# 1.1 Louth County Council: Further Information Request

### **FURTHER INFORMATION REQUEST**

**RE: Permission for the construction and operation of a new Effluent Balancing and Resource Recovery Plant (EBRRP) on a site of 7.888hectares, which will consist of: (1) Excavation of the site to facilitate the proposed development, and reuse of excavated material as a landscaped spoil heap within the site; (2) Construction of 3no. covered structures containing 12no. process tanks, located within concrete bunds with metal stairwells and platforms for access, and connected to an odour treatment facility. (3) Installation of 5no. covered storage tanks located within concrete bunds with metal stairwells and platforms for access. (4) Installation of a sludge dewatering facility. (5) Construction of a single-storey administration and process building with roof-mounted solar panels and rainwater harvesting tank. (6) Widening of an existing access on the Mullagharlin Road and associated setback of the existing hedgerow, to facilitate a temporary construction access and a permanent operational access for small vehicles. (7) Construction of a fabricated metal access bridge and pipe and cable suppo

TEMPORARY CONTRACTORS COMPOUND - REFER TO FGCL DRAWINGS 1011-000121-M6-XX-XX-DR-M-1104 SITE ELEVATIONS 01
1011-000121-M6-XX-XX-DR-M-1105 SITE ELEVATIONS 02
AREA TO BE FULLY REINSTATED TO MATCH EXISTING PRIOR TO COMMENCEMENT OF THE DEVELOPMENT (GRASS SEEDING).

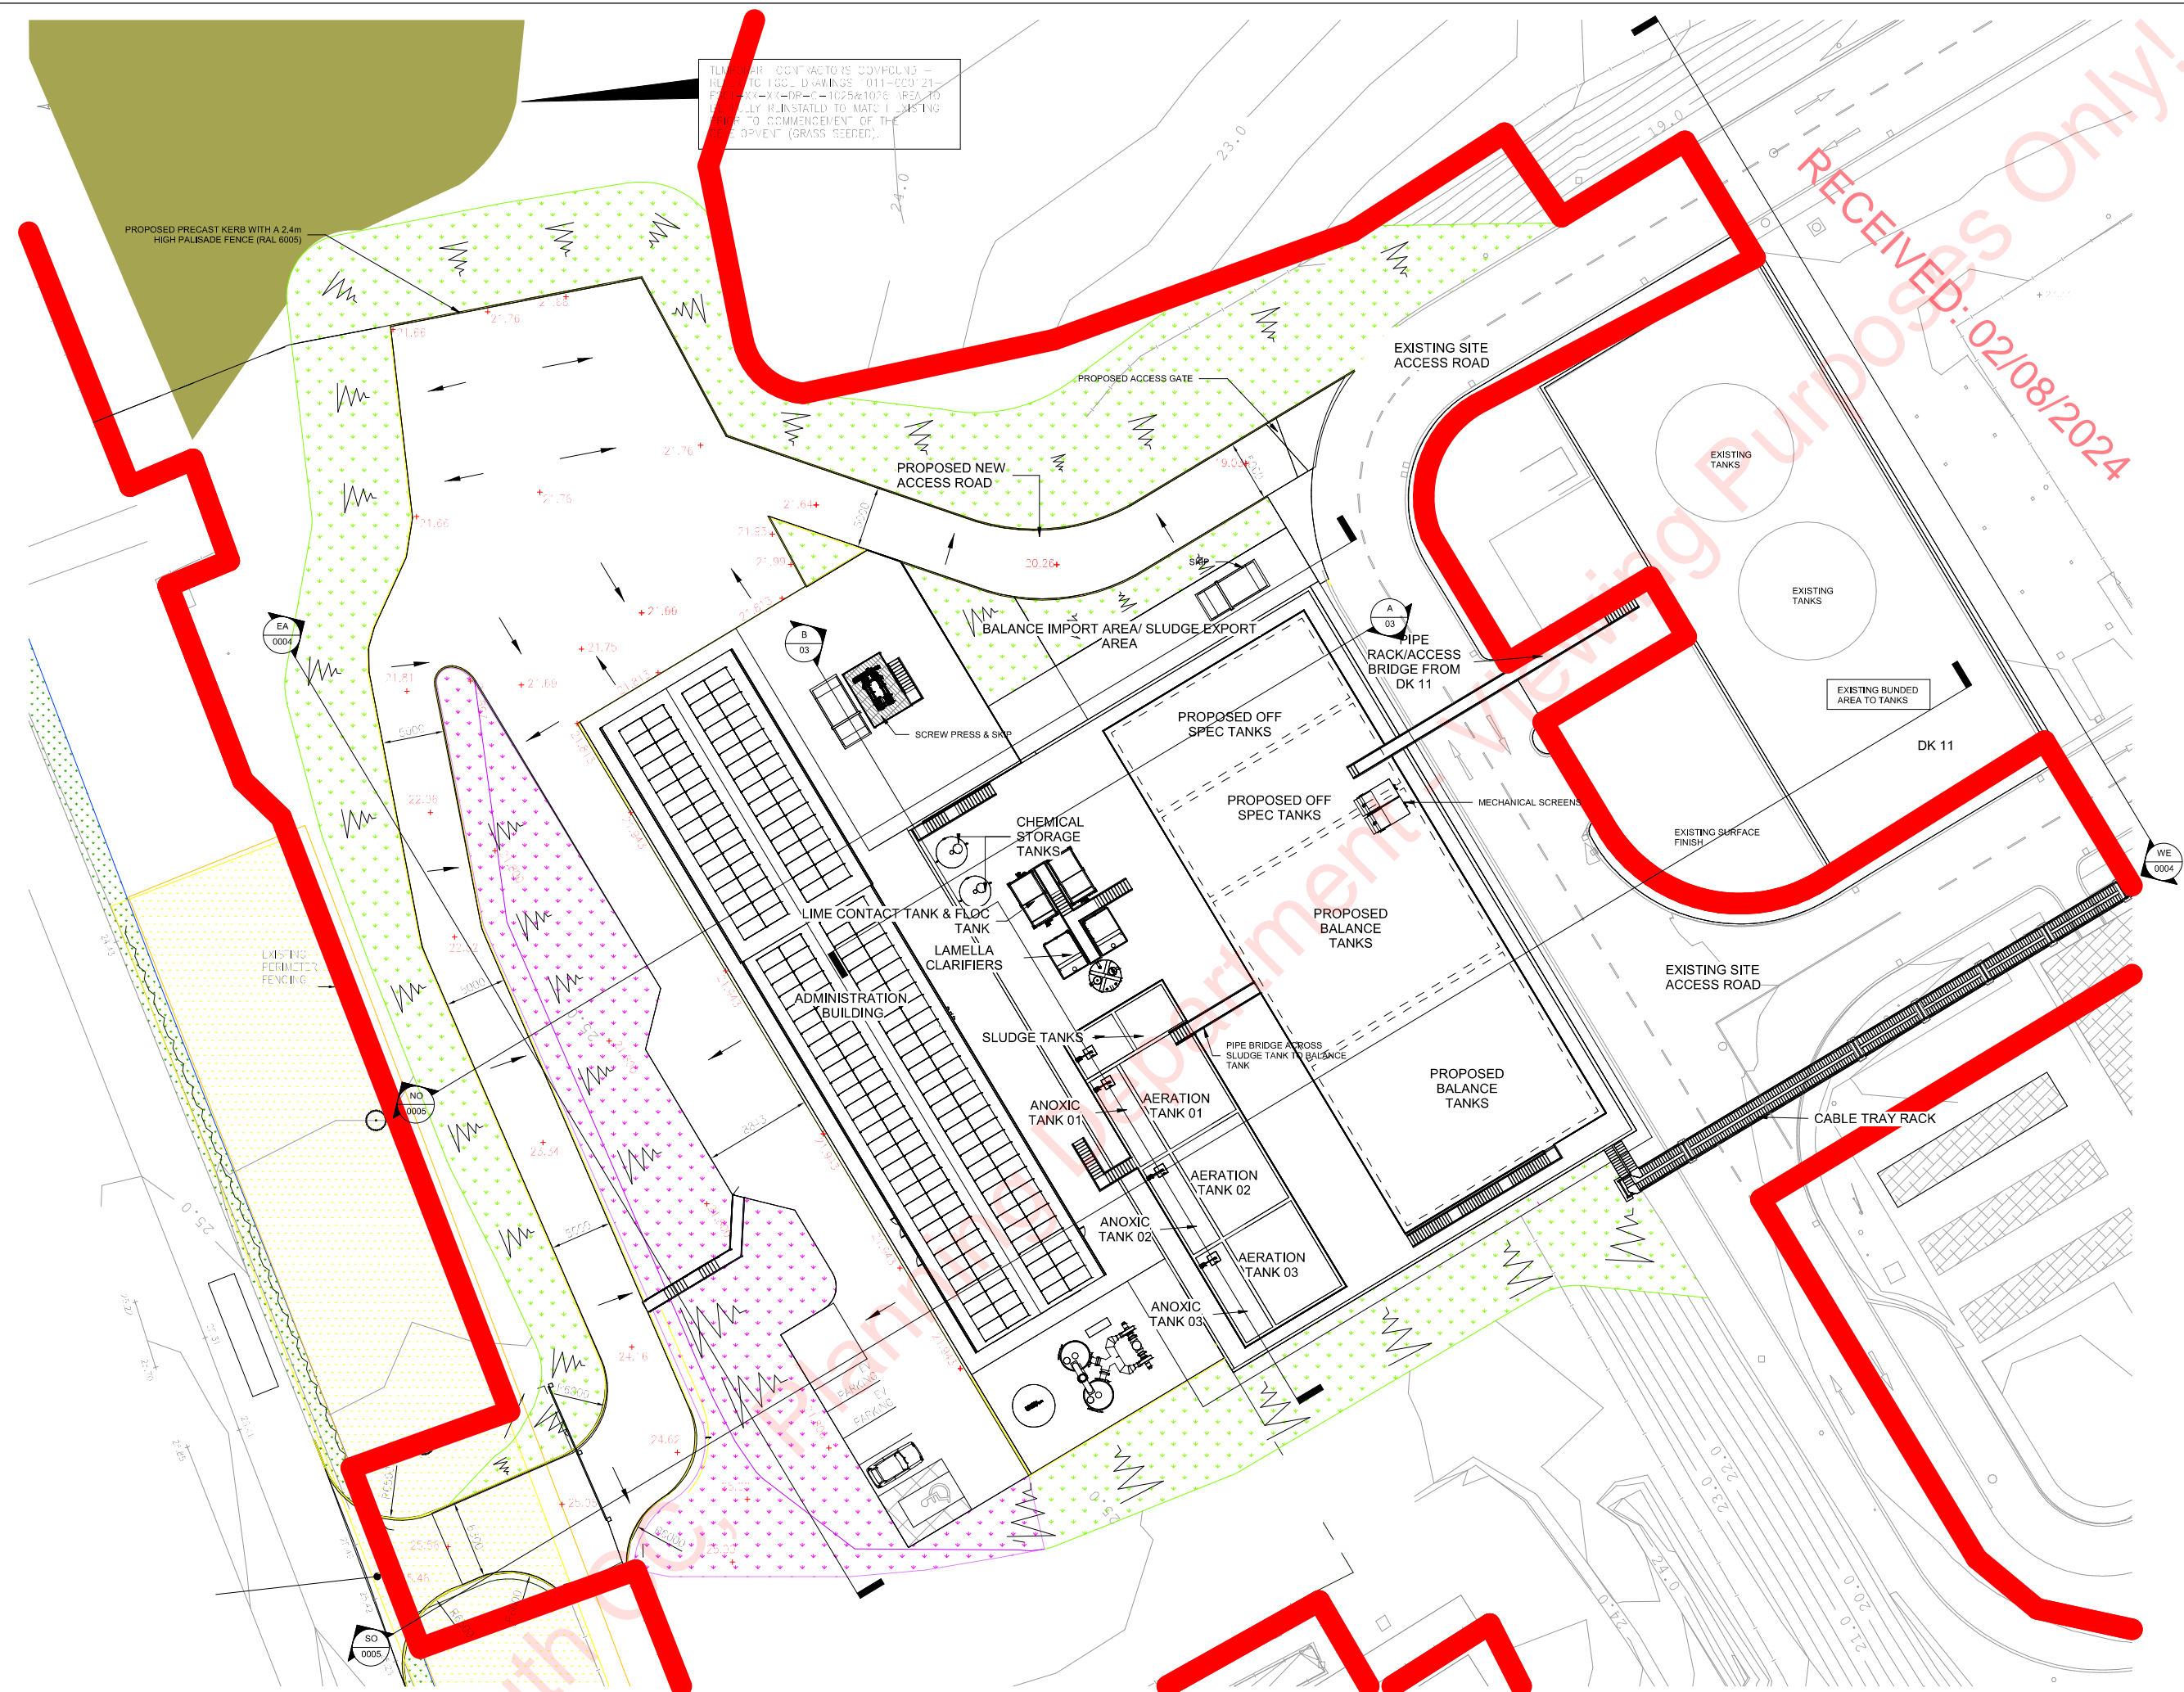
1. The Planning Authority has concerns in respect of the location of the temporary construction compound relative to the archaeological features on subject site. The noted sites of recorded monuments include the following Souterrain (LH012-055----); Enclosure (LH012-102---) and Ring ditch (LH012-101----).

Accordingly, the applicant needs to consider the relocation of the compound or alternatively siting or mitigation to ensure that the Recorded Monuments and identified archaeological features and deposits located within the site of the proposed development are not impacted upon in anyway.

- The chemical delivery area will be moved further west in line with the reduction in bund footprint.
- The fire access road will be moved further south in line with the reduction in bund footprint.
- The construction compound will be moved further south and significantly reduced in extent in line with the reduction in bund footprint.

All of these changes will result in a reduction in the overall footprint of the tanks, bund and compound area to ensure that the recommended buffer zones around the Recorded Monuments within the site of the proposed development will not be impacted and to minimise the risk of impact on other archaeological remains (see Figure 8).
